1. **SEGRO Properties Limited, for an order granting development consent order for a Scheme comprising the East Midlands Gateway Phase 2 (EMG2) Works**
2. **SEGRO (EMG) Limited, for an order making material changes to the previously approved East Midlands Gateway Rail Freight Interchange and Highways Order 2016**

The Examining Panel's written questions and requests for information (ExQ2): Issued on 2 June 2026

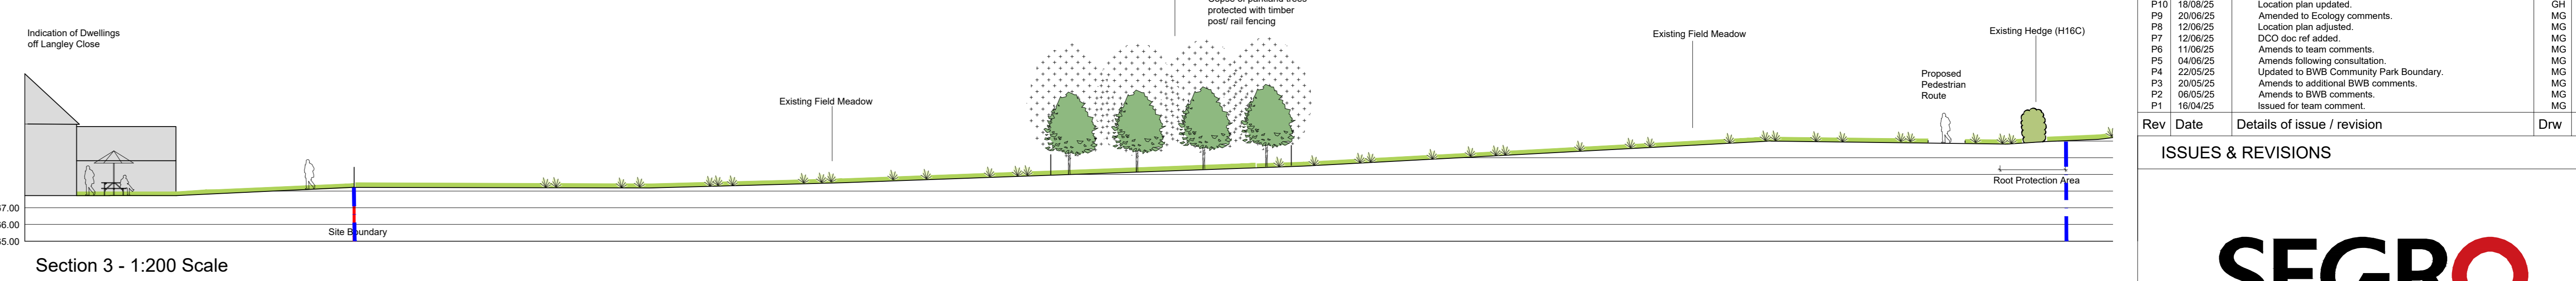
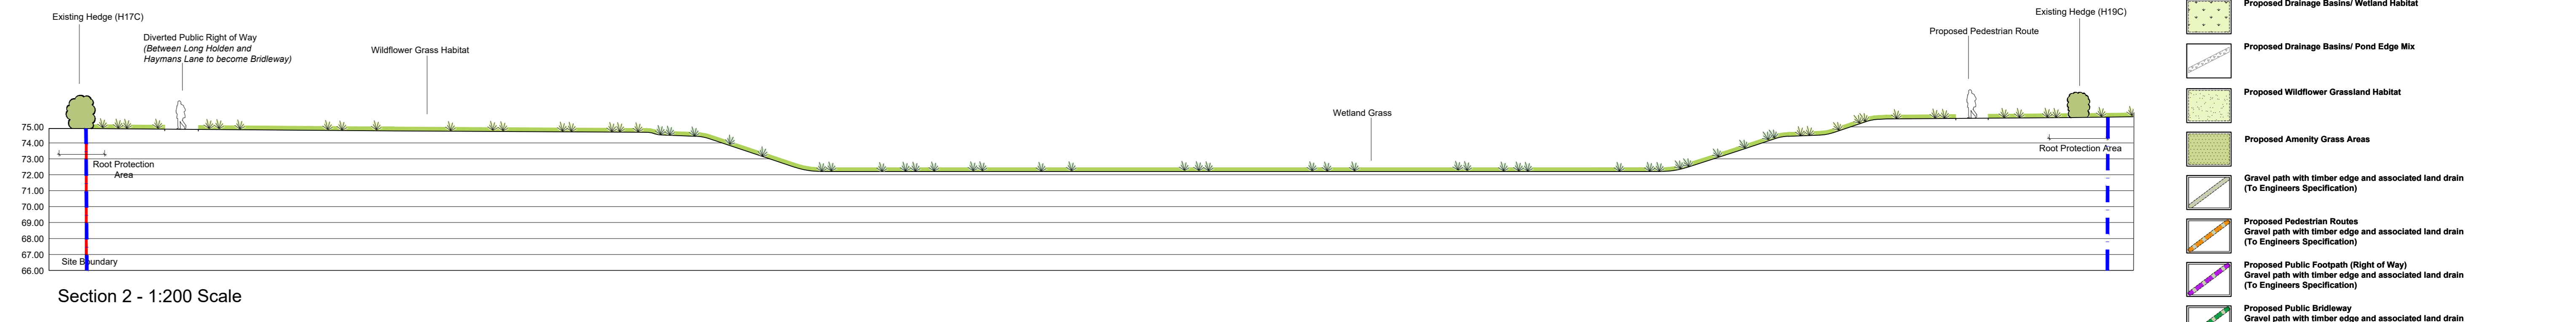
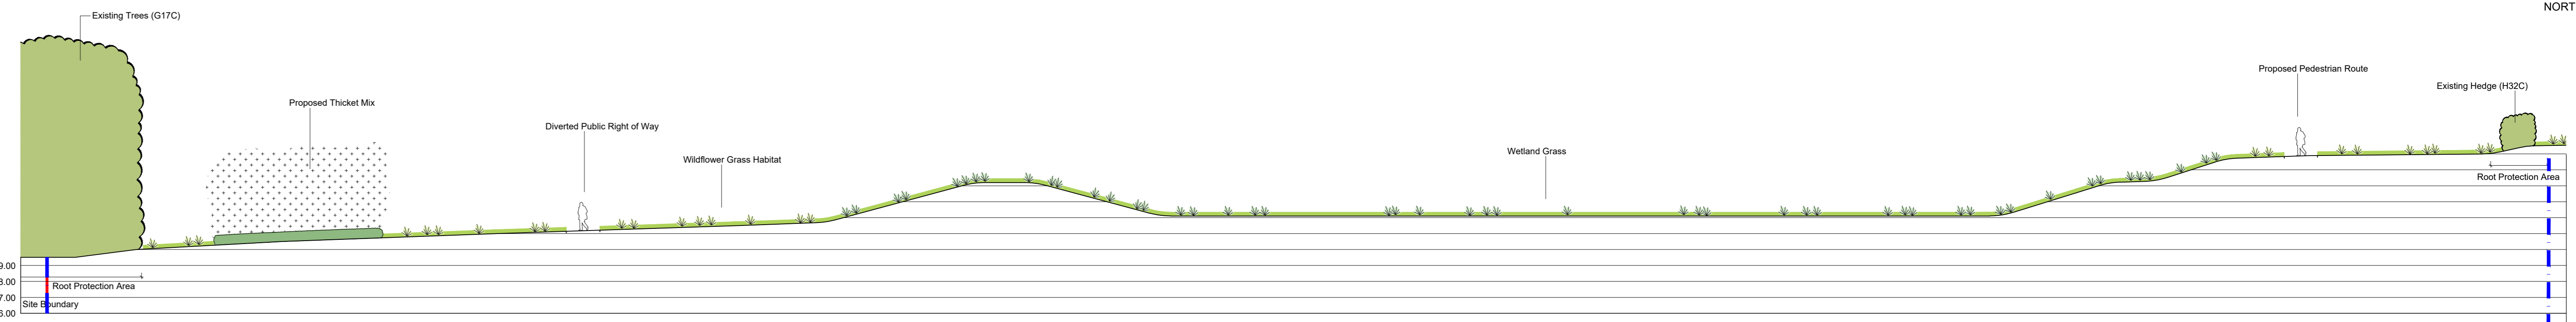
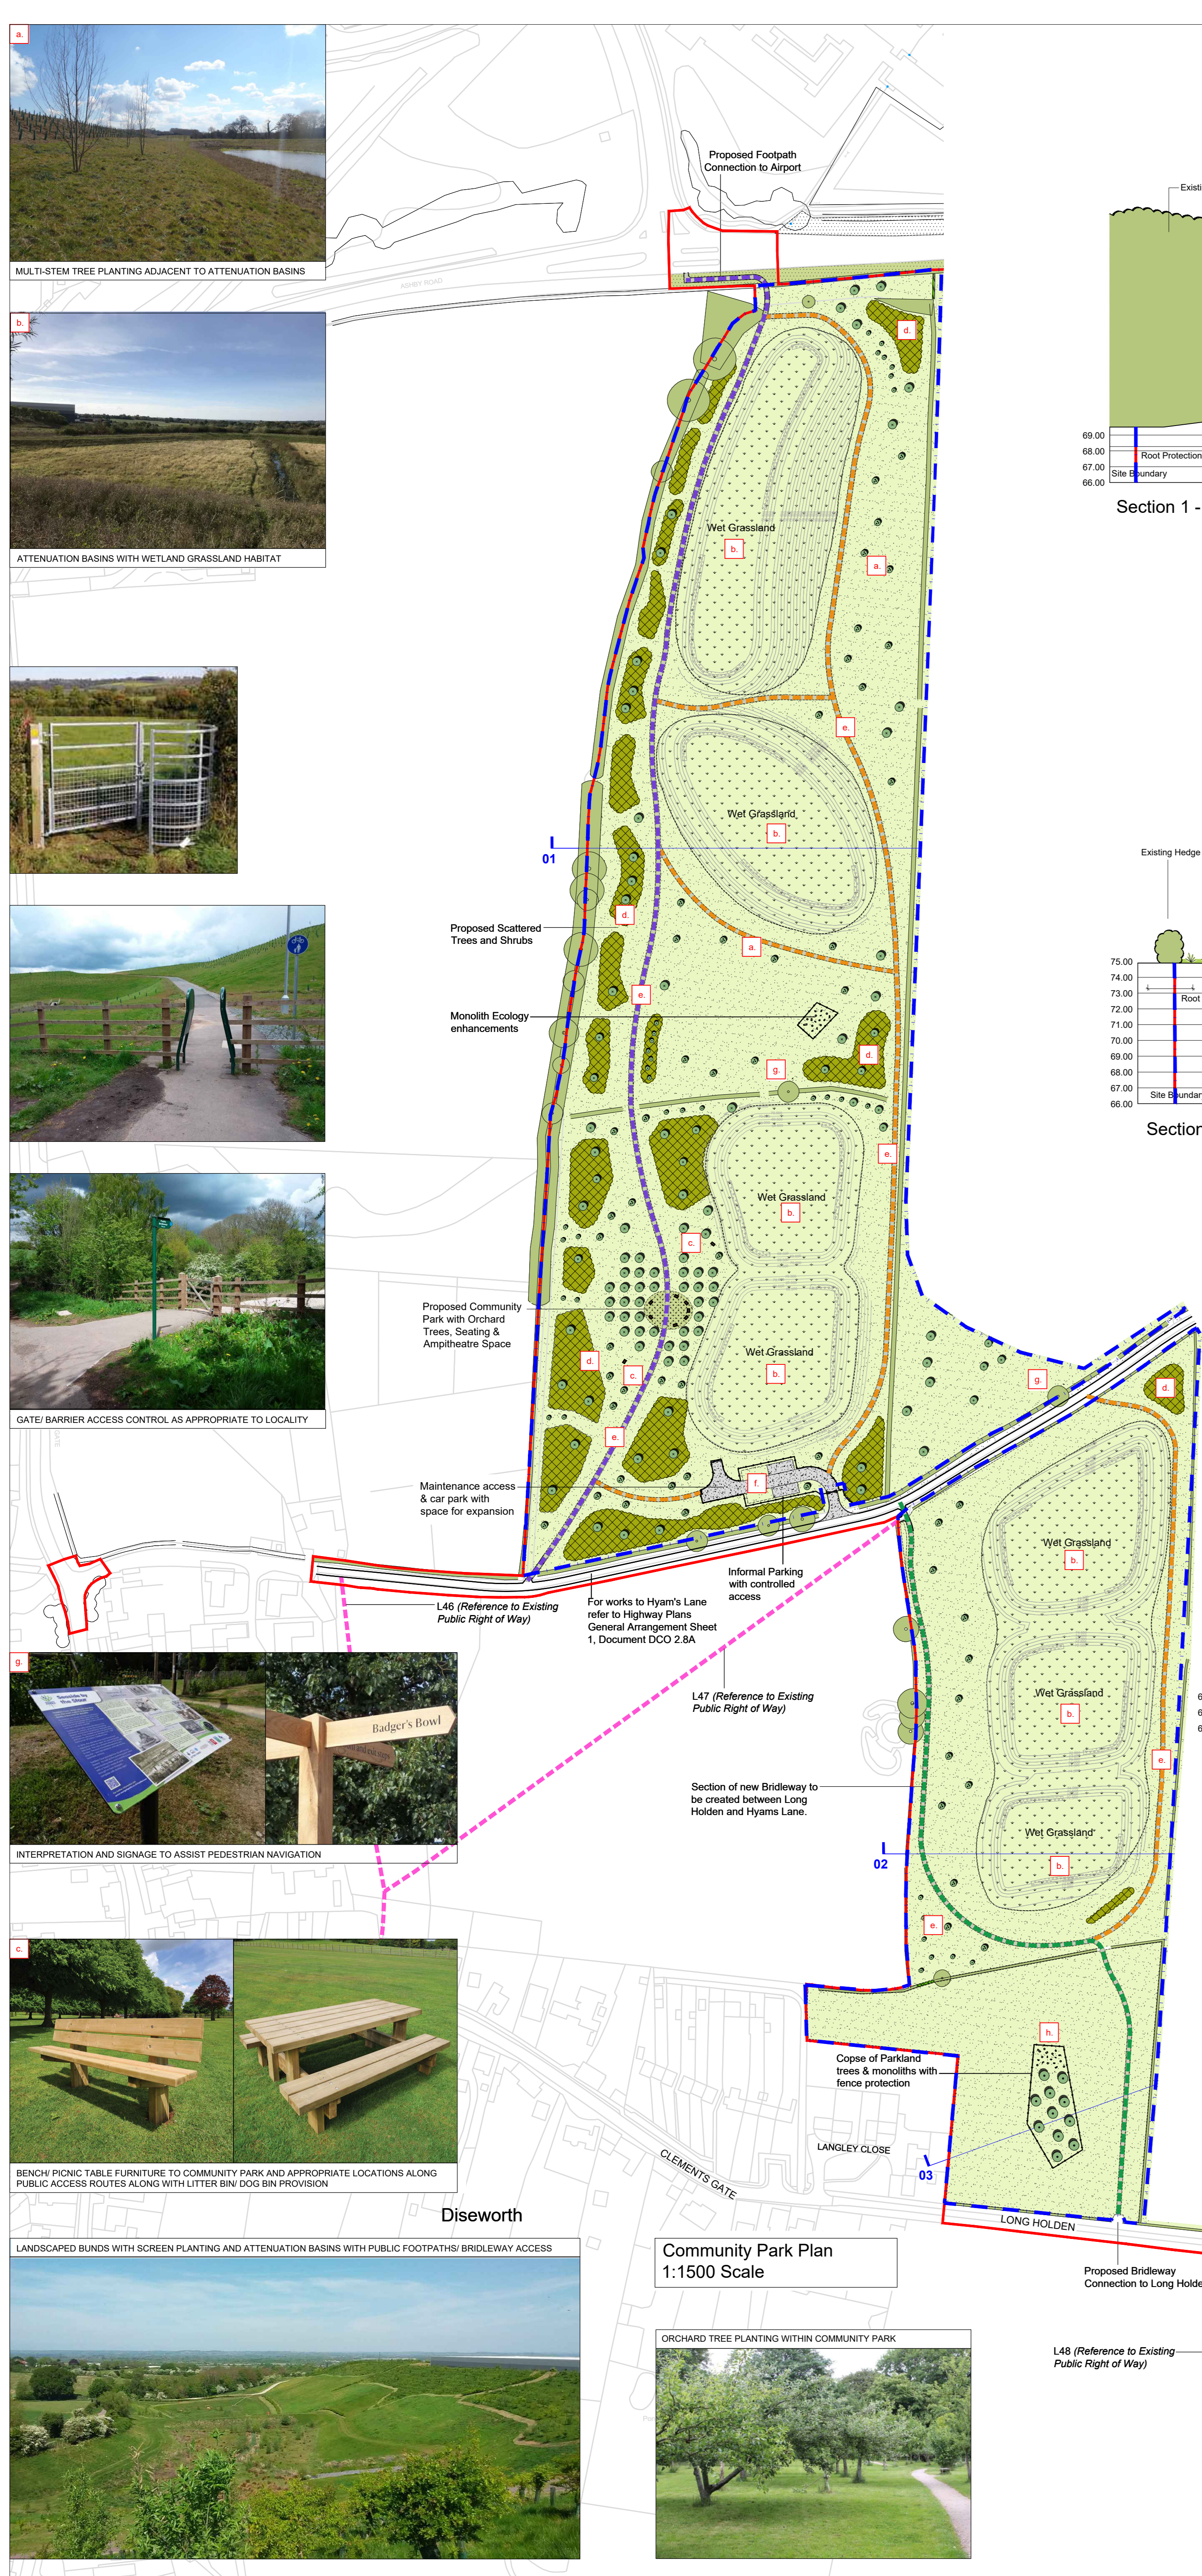
1.2 Community matters		
Q1.2.1	The applicants	<p>Community park</p> <p>In light of annexure 1G in the responses to the ExP's written questions [REP1-054] the applicants have provided a plan showing the areas across the site where gradients are greater than 1 in 8. Given the extent of this across the northern part of the open space area, could the applicants explain how this would be made accessible for all, and particularly how those requiring lesser gradients travelling across the open space to the north and the A453 so that they would be able to access this.</p>
Q1.2.2	The applicants	<p>Community Park Plan</p> <p>The issue of competing usage across the community park has been raised in relation to several issues. In this context, please can the applicants provide a community park plan that shows all the relevant components and the associated space requirements of each, including any buffer zones or design standards required by policy or guidance. The role of the plan is to demonstrate to the ExP whether all the proposed components therein can be accommodated without any unacceptable spatial conflicts or tensions.</p>
